Client
SPALDING RECTORY PARISH

Project
EXTERIORS TO FORM PARISH OFFICE
AT THE COACH HOUSE
HARREL COTE
SPALDING, Lincs.

Drawing
Plan & ELEVATIONS AS PROPOSED

ground floor plan

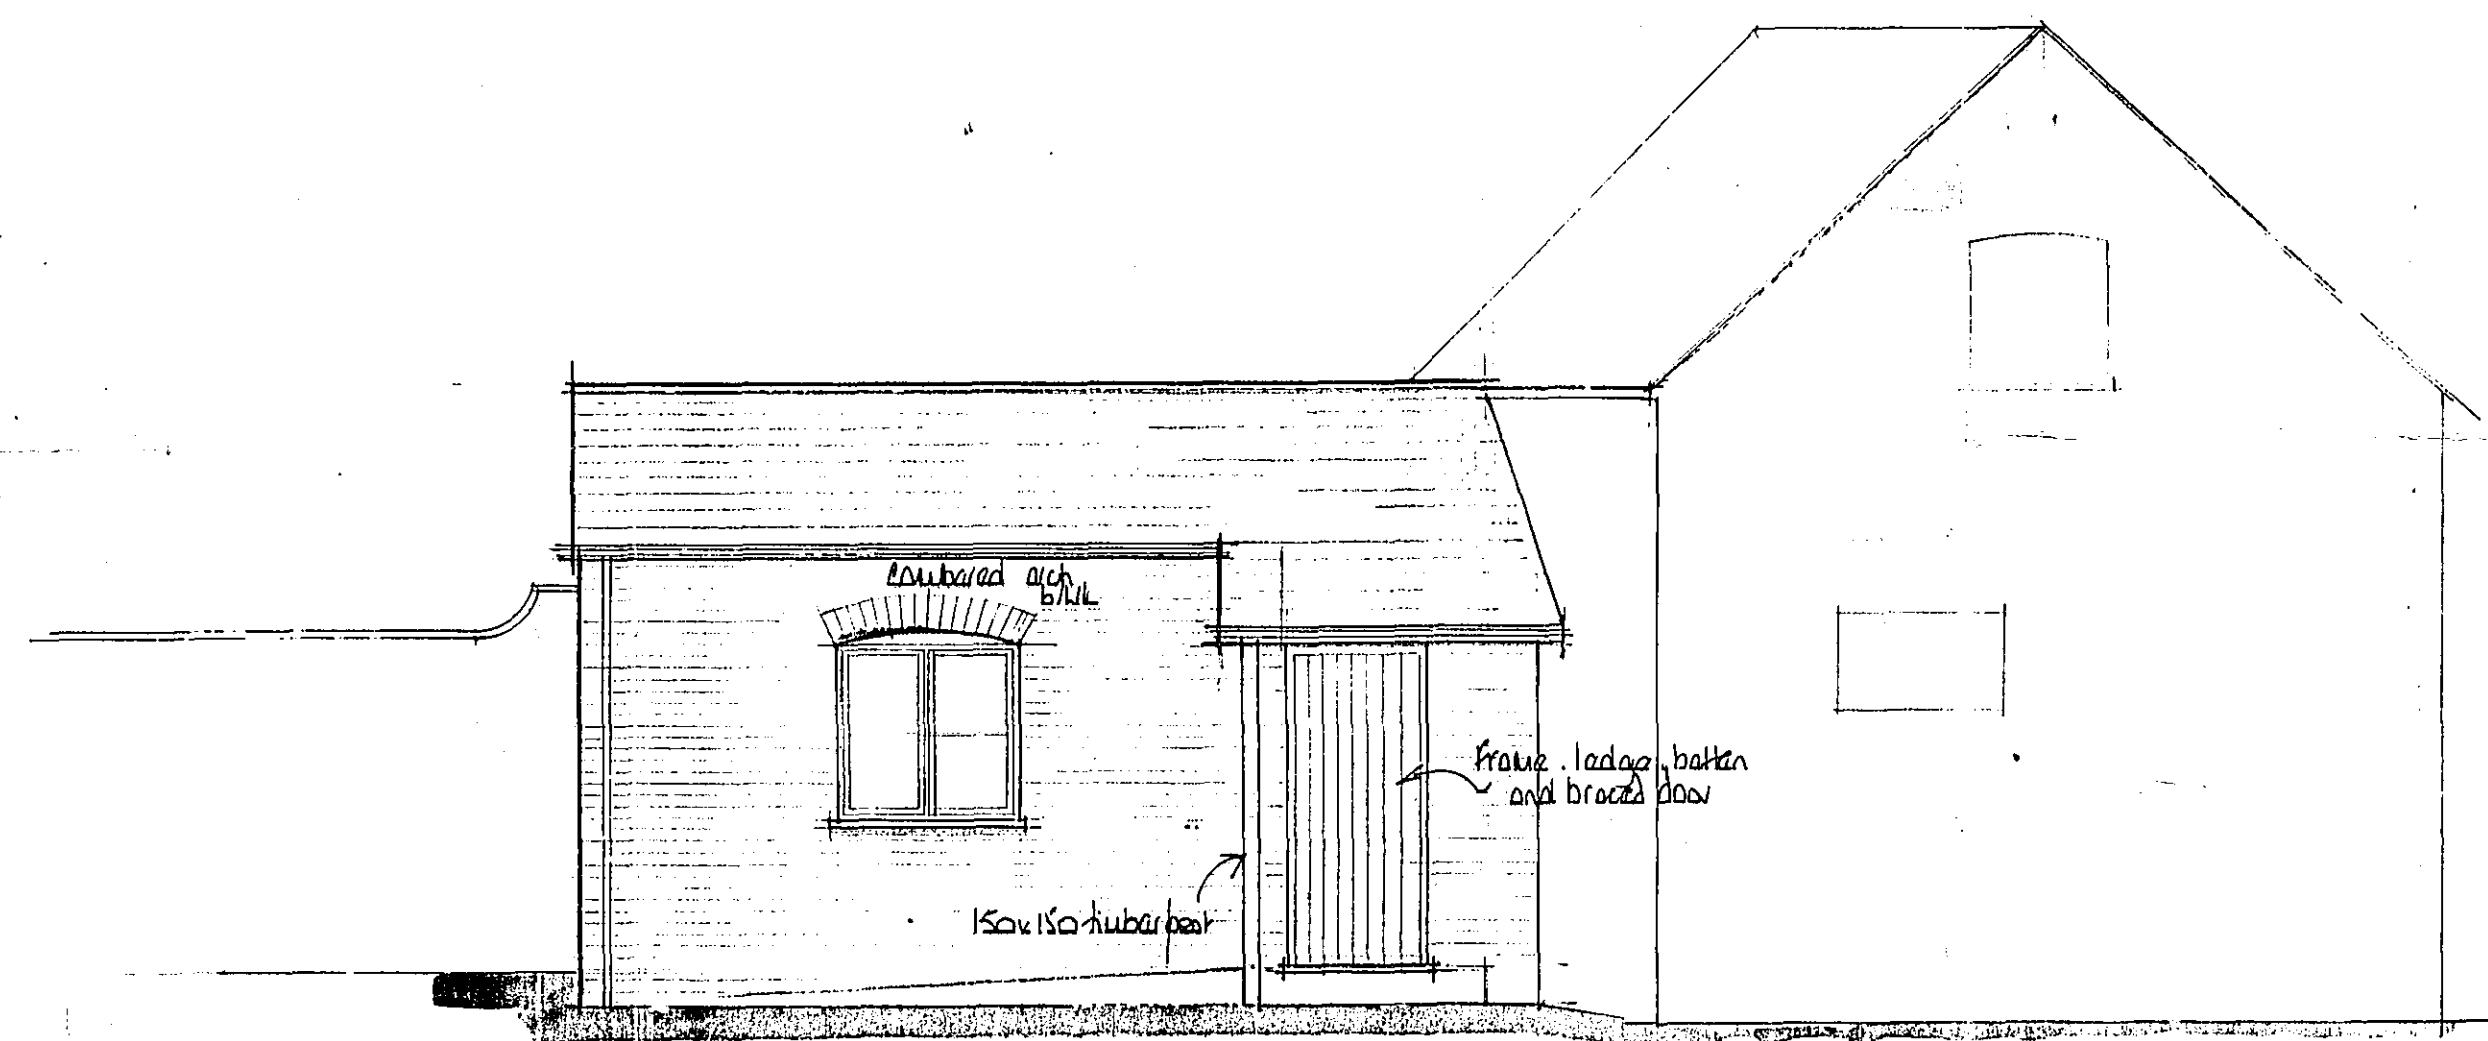
of West window!!
+ arch
to Ruler!!
rest of the

John
Plan left for
your consideration / comment
by Andy Lowrie
17/2/05
